From: Dominic Smith [REDACTED]
Sent: 06 January 2015 14:55
To: Peter Cleveland
Subject: A/154/14

Access

Internal Layout

SITE PLAN

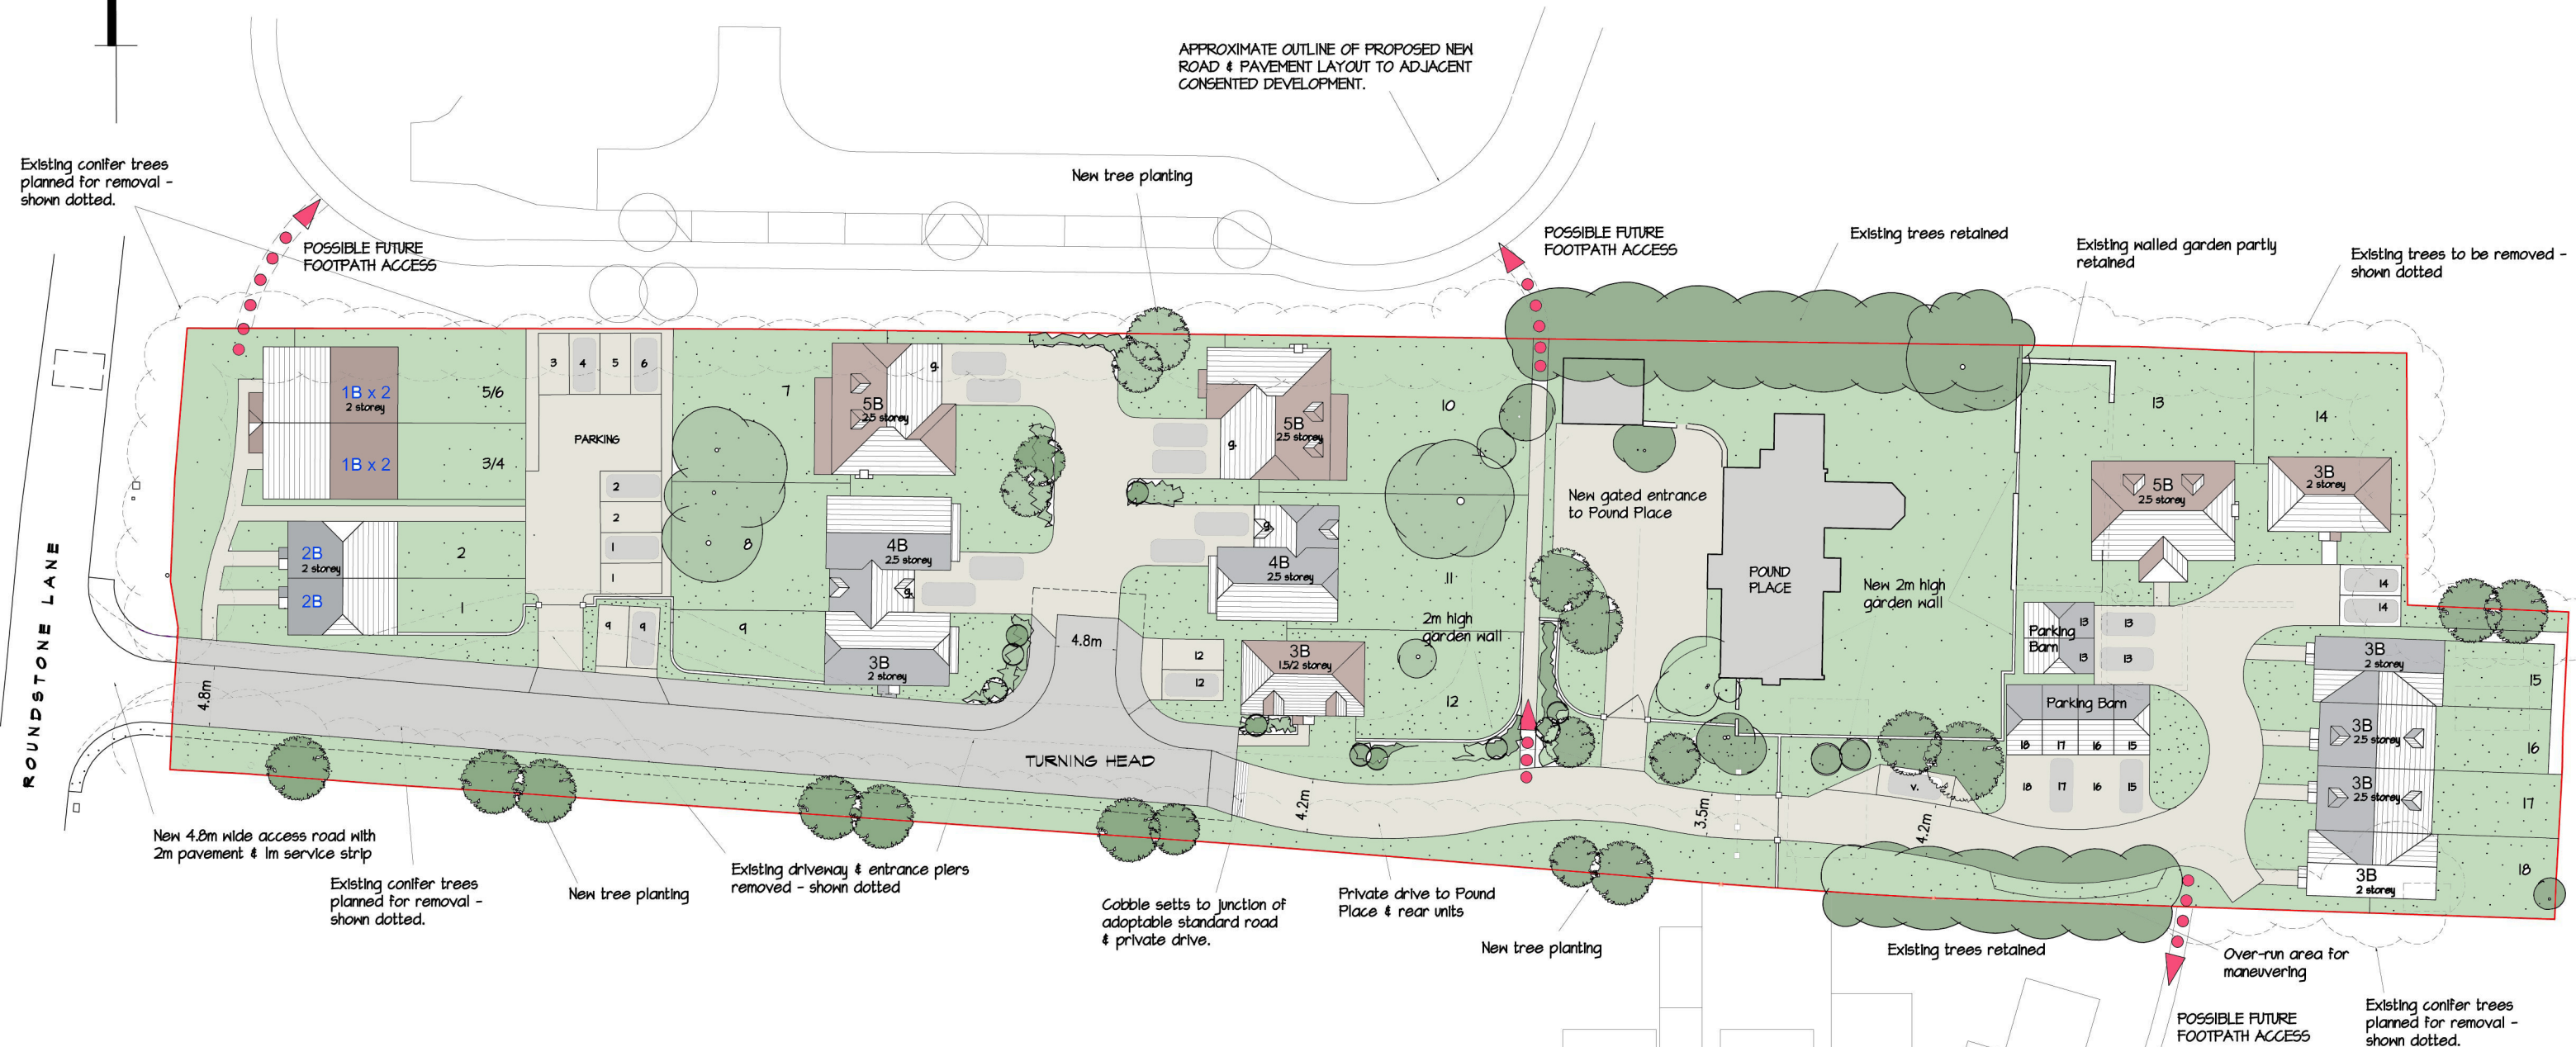
Improvements should be made to the footway connectivity, with the provision of a dropped kerb/tactile paving crossing location to the east and west of Roundstone Lane. This is likely to require a short extension to the footway on the eastern side of the carriageway to facilitate a straight crossing of Roundstone Lane.

Visibility splays have been identified within the transport assessment but should be shown on the site access plan to enable their conditioning.

Whilst I note that permission is sought for access only I can offer the following comment on the internal layout. Tracking should be undertaken to demonstrate that the internal roads can accommodate the movement and turning of a refuse vehicle.

The alignment of the internal road is straight and its length could encourage vehicles to travel at inappropriate speeds; I would suggest that either the alignment is altered or that features are introduced to discourage higher vehicle speeds.

The carriageway width narrows to 3.5m at the eastern part of the development. I would recommend that a minimum road width of 4.1m is maintained at the shared use sections.
